Stonestreet Green Solar

Appendix 1.3: EIA Scoping Opinion Compliance

PINS Ref: EN010135

June 2024

Figure 10.1

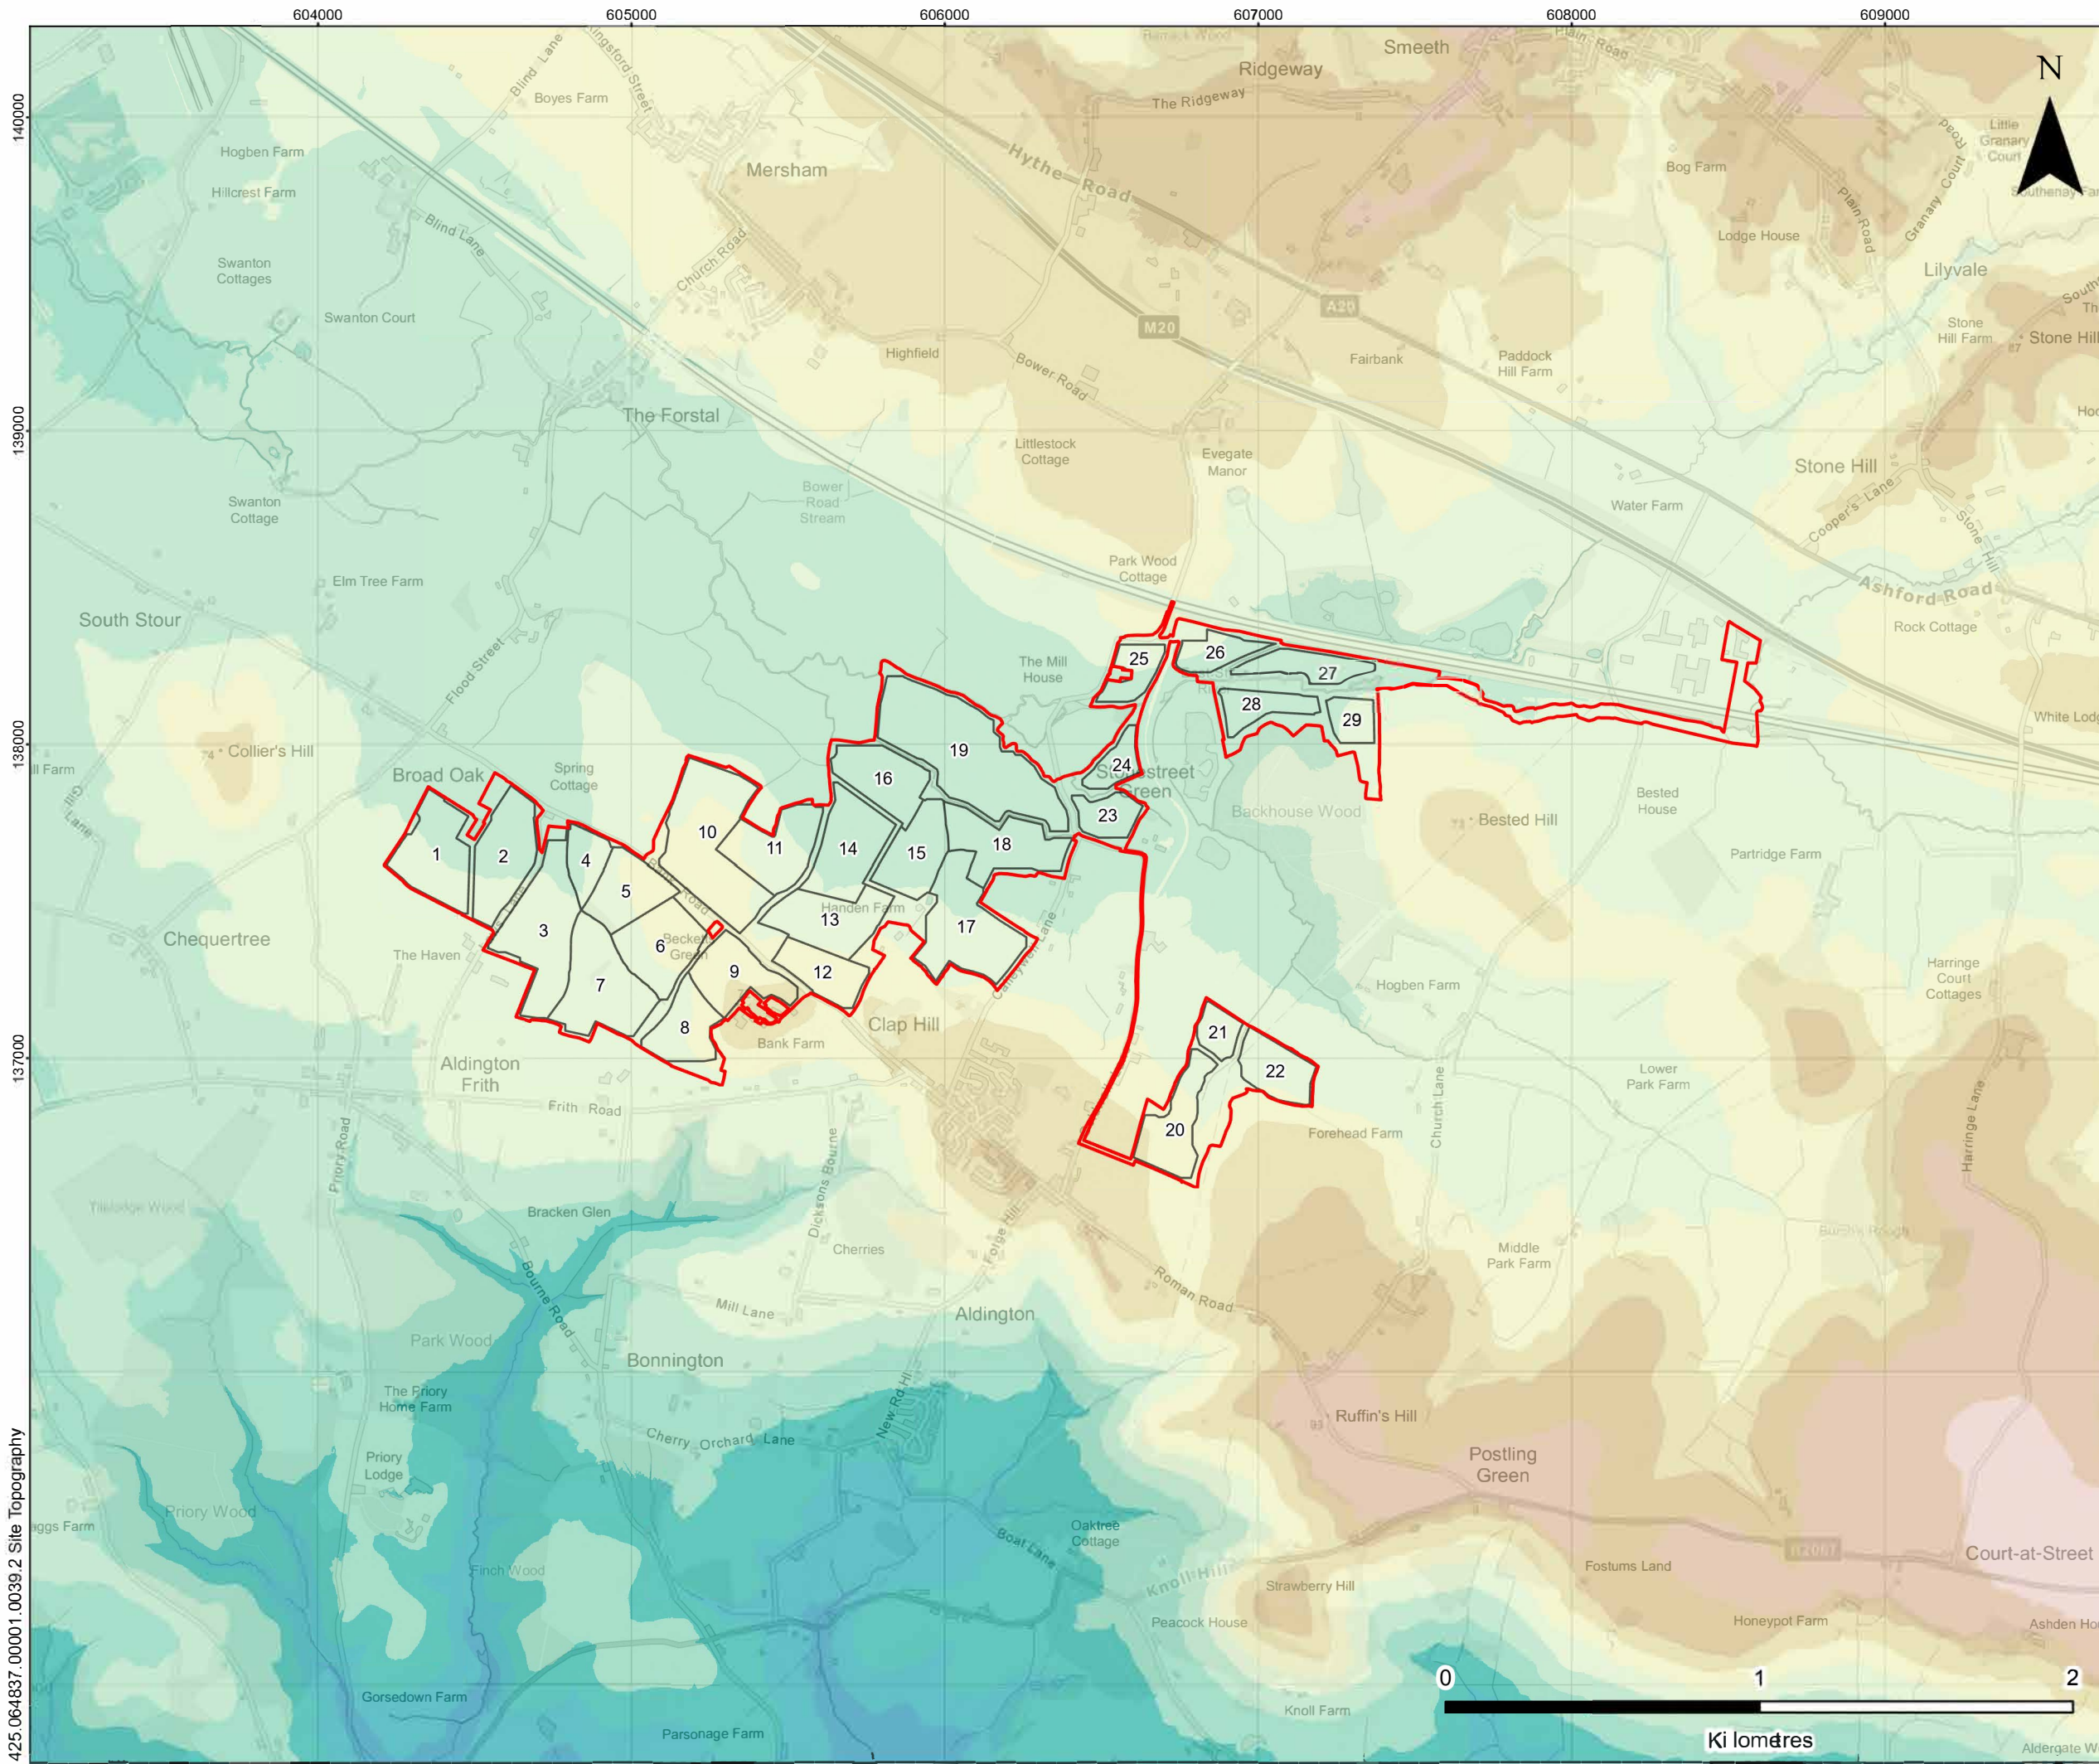
PINS ID	PINS Ref.	Description	PINS' Comments	Commentary
2.2 EIA Methodology and Scope of Assessment				
2.2.1	11.3.2 and Figures 9, 12, 15	Figures and study areas	It is noted that a number of figures are suggested to show study areas but do not do so. For example, Figure 9 does not display the 2km and 10 km site buffers for biodiversity although they are included in the 'Legend' therefore it is unclear which designated sites are in the study areas. Additionally, Scoping Report paragraph 11.3.1 states a 2km buffer from the site boundary for the water environment will be used as a study area and that this is shown on Figure 12 however, no study area is defined on Figure 12. Figure 15 identifies Public Rights of Way ('PRoW'), but these do not correspond with those described in Scoping Report paragraph 12.4.15. The ES should identify the study area clearly on an associated Figure and describe why the study area is appropriate for each of the aspect chapters assessed where relevant.	Each aspect / topic chapter of the ES (ES Volume 2, Chapters 7-15 (Doc Ref. 5.2)) includes a section titled 'Study Area' under 'Assessment Methodology' which signposts where the corresponding figure that shows the relevant study area for the assessment (if applicable) is located. Assessment Methodology sections of each topic chapter also describe why each study area is appropriate for the particular aspect chapter.

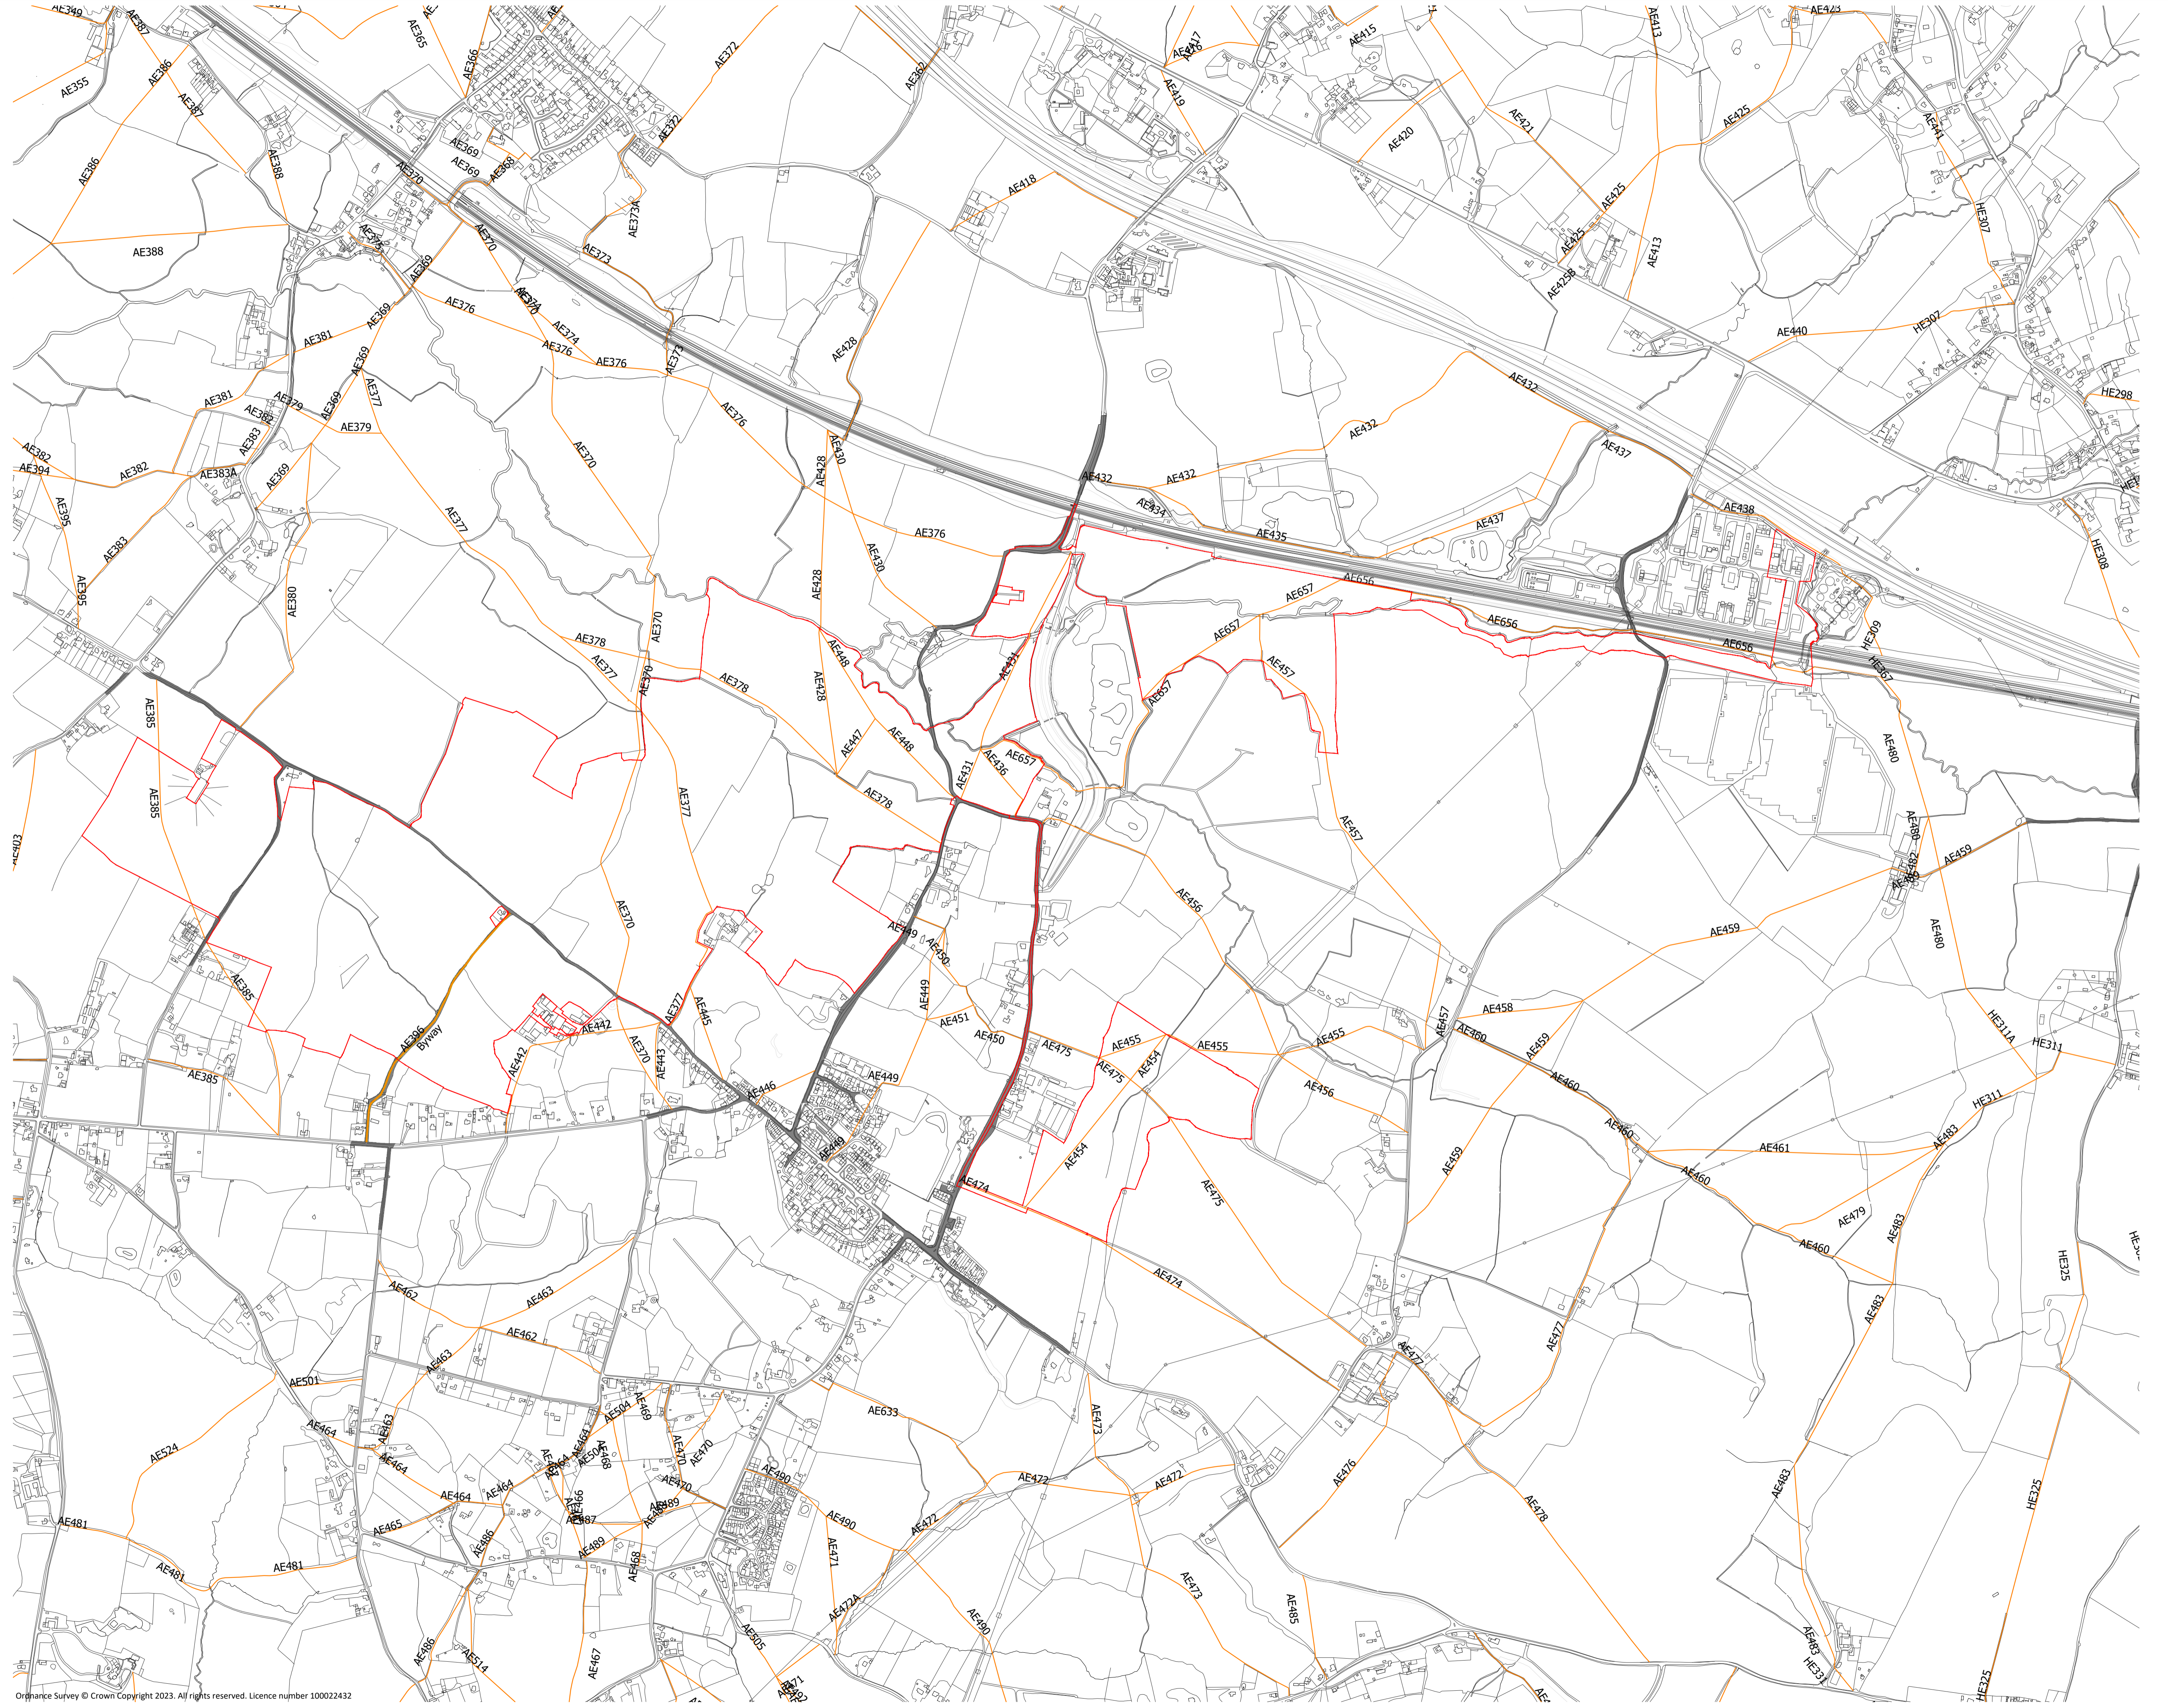
2.1.2	4.2.4, 4.4.1 and 4.4.3	Construction compounds and access	Scoping Report paragraph 4.2.4 states that there will be 'one or more temporary construction compounds' and 4.4.3 states that the ES will describe the design and location of these compounds and accesses. The ES should explain how the optioneering process to locate both accesses and	ES Volume 2, Chapter 3: Project Description, Sections 3.10 and Section 3.11 (Doc Ref. 5.2) provide a description of the primary construction compounds and primary site access which will be located in the north of the Site. Secondary construction compounds and laydown areas will also be used on a temporary basis.

PINS ID	PINS Ref.	Description	PINS' Comments	Commentary
			<p>construction compounds has sought to avoid or minimise impacts on human and ecological receptors. Where appropriate, existing accesses should be utilised and consideration should be given to the appropriateness of accesses for Heavy Goods Vehicles ('HGVs') and/or abnormal loads e.g. weight restrictions, width restrictions, turning area etc. Relevant measures to reduce construction traffic routing and access impacts on the local network should be agreed relevant highways authority, where possible.</p>	<p>Existing site accesses will be utilised for the construction stage of the Project wherever possible.</p> <p>Information on the Site access arrangements and the appropriateness of accesses for HGVs is provided in ES Volume 2, Chapter 13: Traffic and Access, Section 13.6 (Doc Ref. 5.2) and ES Volume 4, Appendix 13.7: Access Drawings.</p> <p>An explanation of the optioneering process to locate both accesses and construction compounds to avoid or minimise impacts on human and ecological receptors is provided in ES Volume 2, Chapter 5: Alternatives and Design Evolution (Doc Ref. 5.2), Table 5.3 under 'Site access' and Section 5.15.</p> <p>Relevant measures to reduce construction traffic together with information on the routing of construction traffic are set out in the Outline CTMP (Doc Ref. 7.9) which accompanies the DCO Application.</p>
